**LRA RESPONSE TO COMMENTS (in red)**  
**6-1-18**

**EL PASO COUNTY PLANNING AND COMMUNITY DEVELOPMENT DEPARTMENT**

## The Reserve at Corral Bluffs Filing No. 2 Transportation Memorandum

THE RESERVE AT CORRAL BLUFFS FILING NO. 2

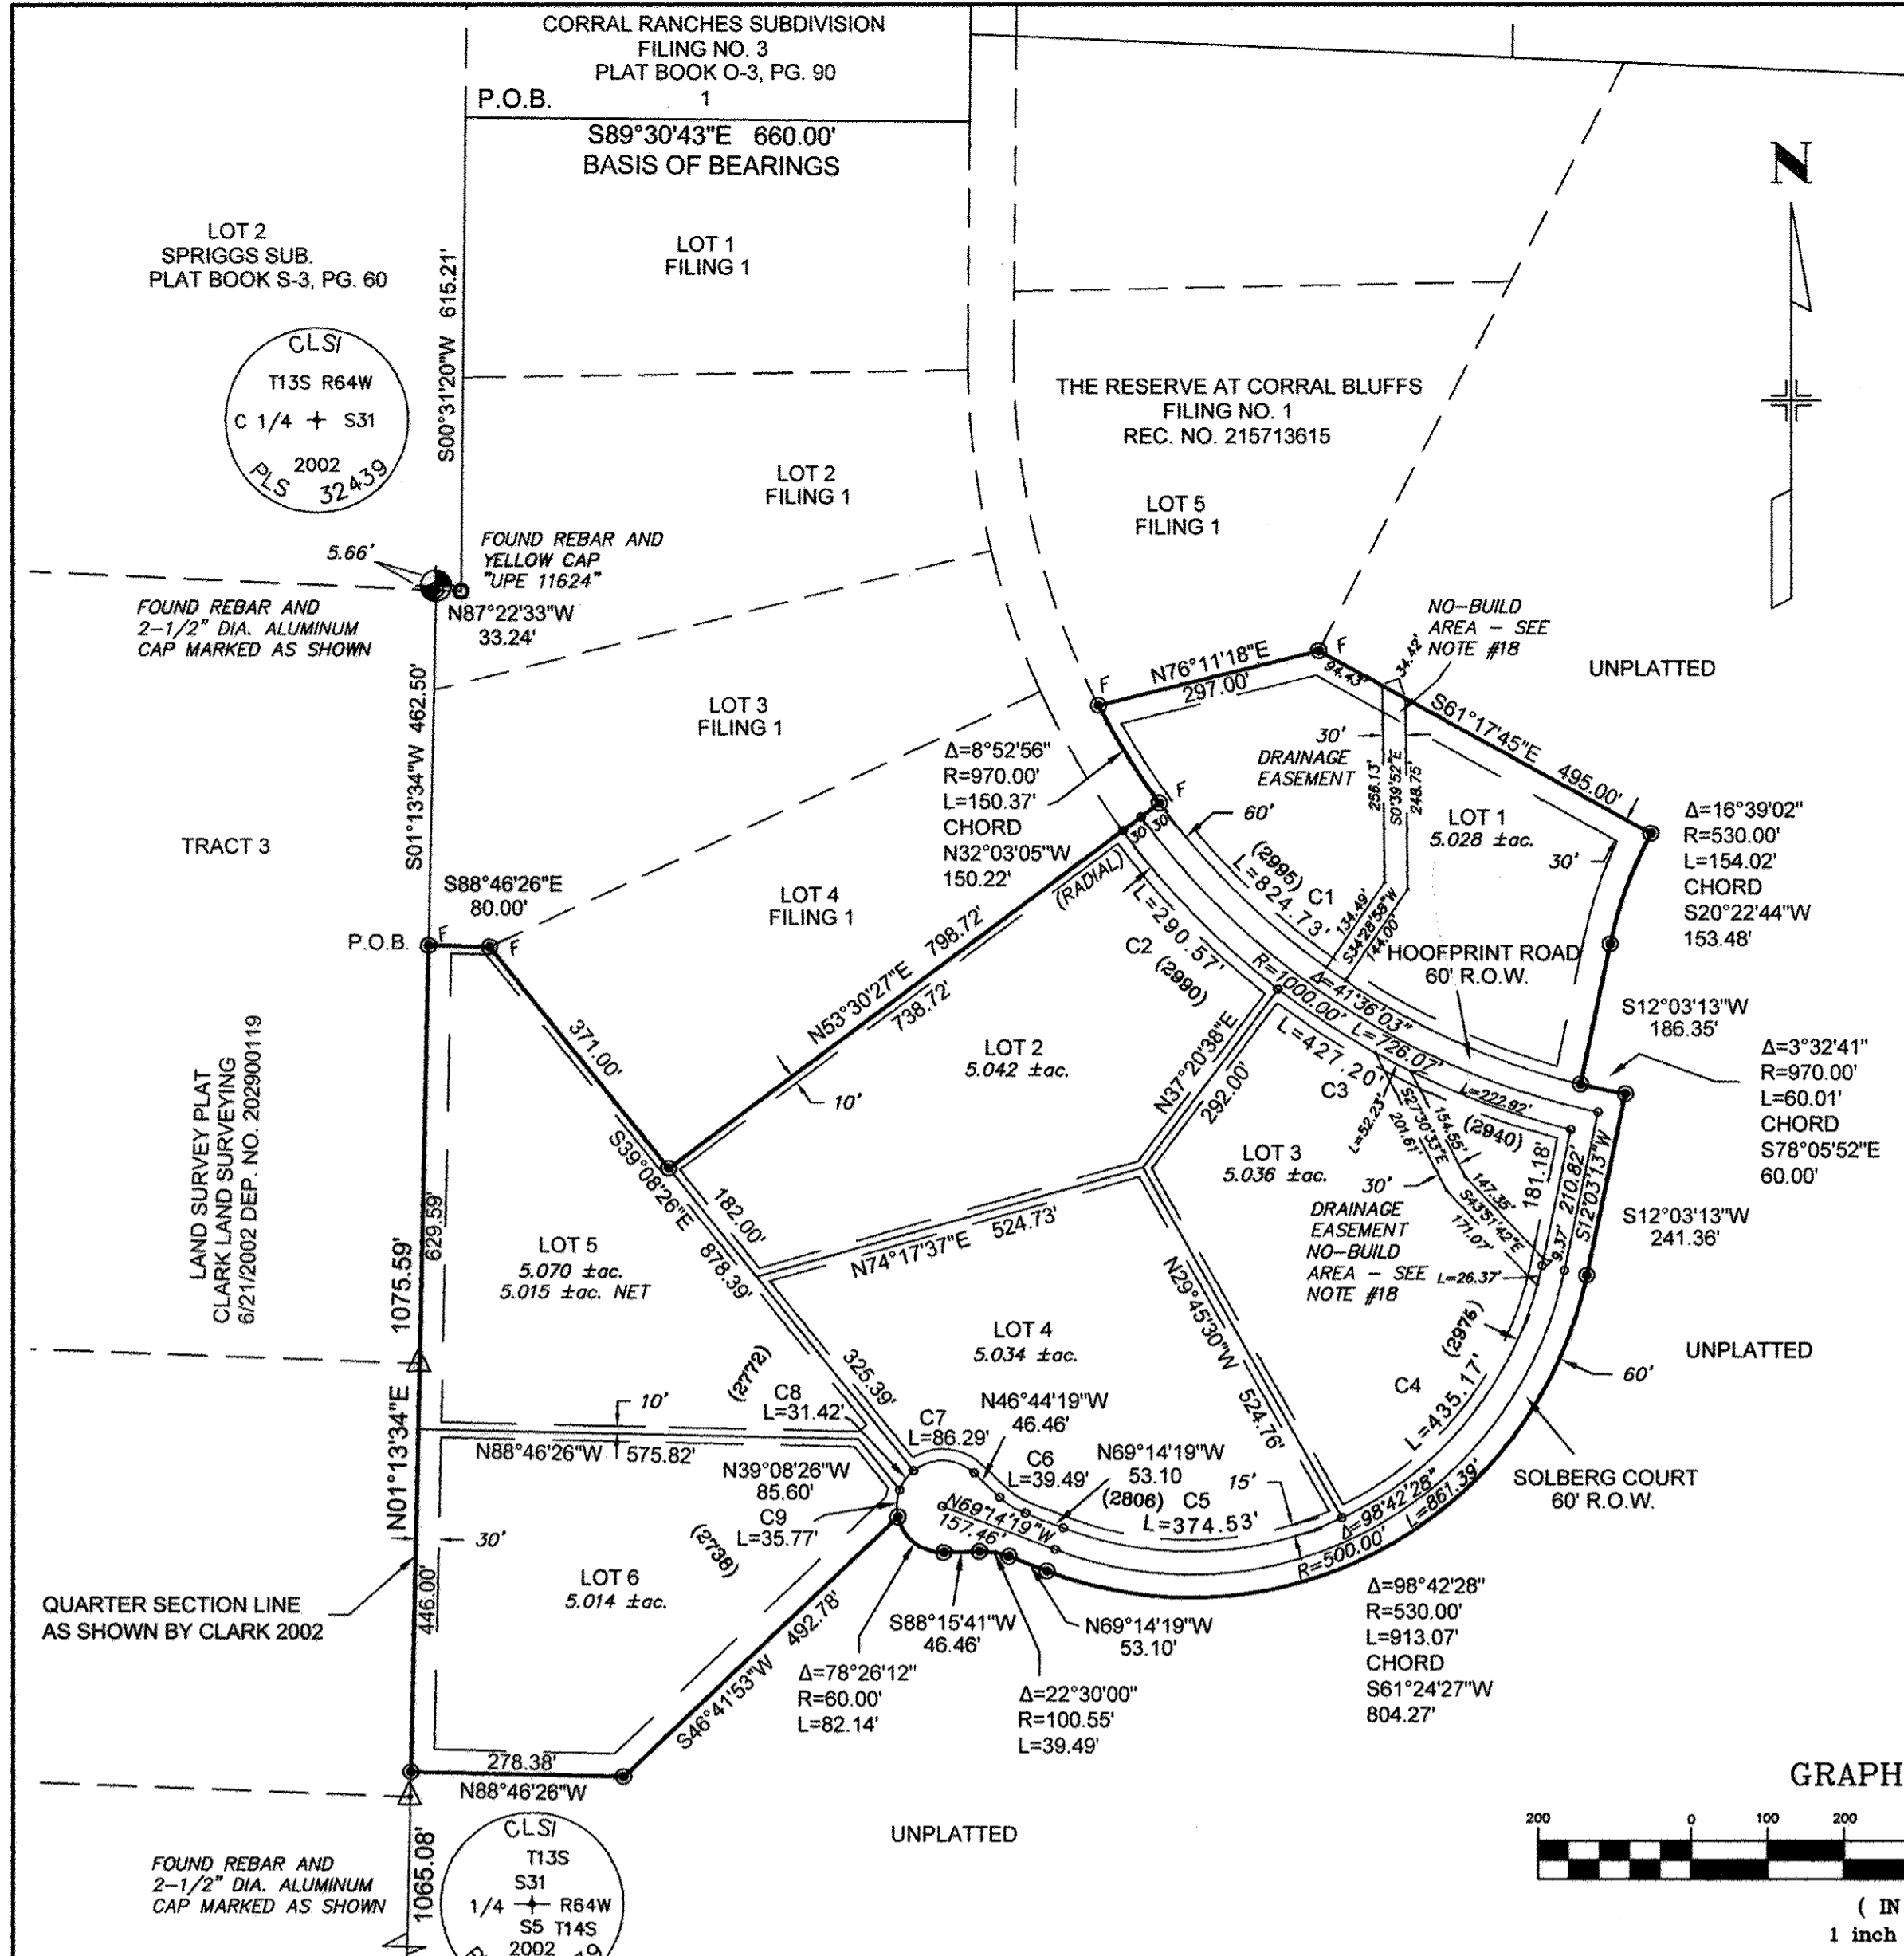
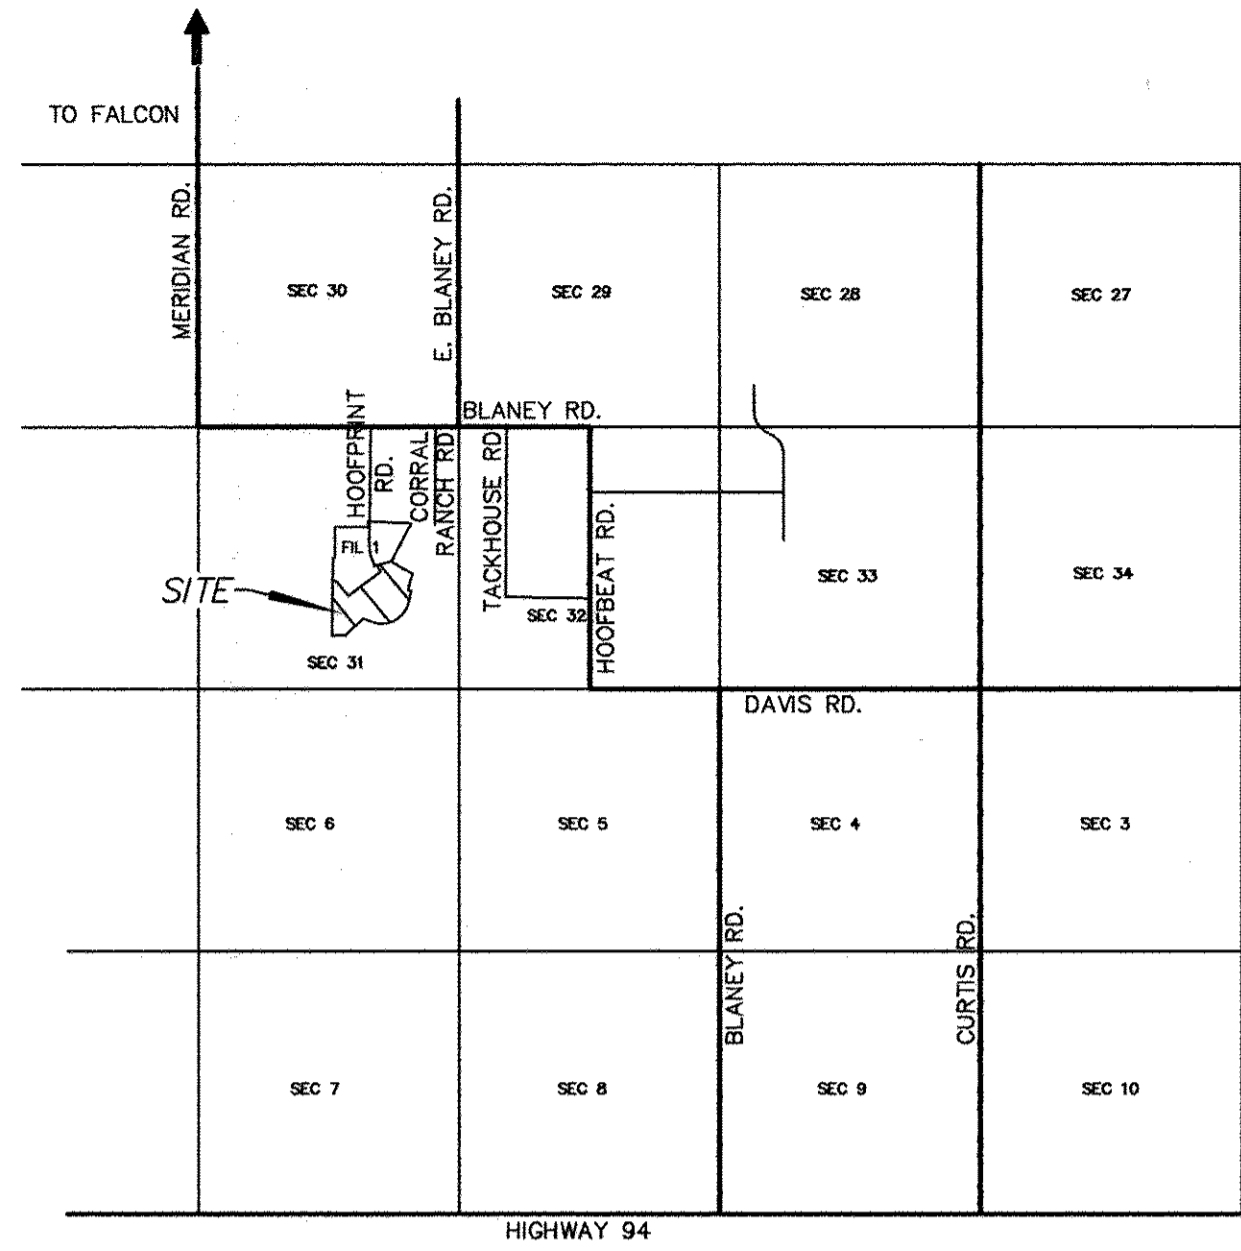
1. Street name SOLBERG COURT, requires approval by El Paso/Teller 9-11 Authority. An email from this department to Enumerations is required.
2. Please show the remaining configuration of Solberg Court so, that the addressing does not get out of order because we cannot see the entire street.
3. In the title block: RANGE 64, TOWNSHIP 13, SEC 31, NORTHWEST QUARTER- should be northeast quarter.

4. Under BOARD OF COUNTY COMMISSIONERS APPROVAL: states this is filing no. 1; this is filing 2.

2. Please show the remaining configuration of Solberg Court so, that the addressing does not get out of order because we cannot see the entire street. **I've attached a pdf copy of the future lots surrounding this phase. You will see the lot and street layout as approved by the preliminary plan. Let me know if you have any other questions or need anything else.**

3. I the title block: RANGE 64, TOWNSHIP 13, SEC 31, NORTHWEST QUARTER-should be northeast quarter. **I disagree. This filing is within the southeast quarter of the section. I did modify the plat and legal to remove the reference to the northwest quarter of the southeast quarter.**

4. Under BOARD OF COUNTY COMMISSIONERS APPROVAL: states this is filing no. 1; this is filing 2. **Revised.**
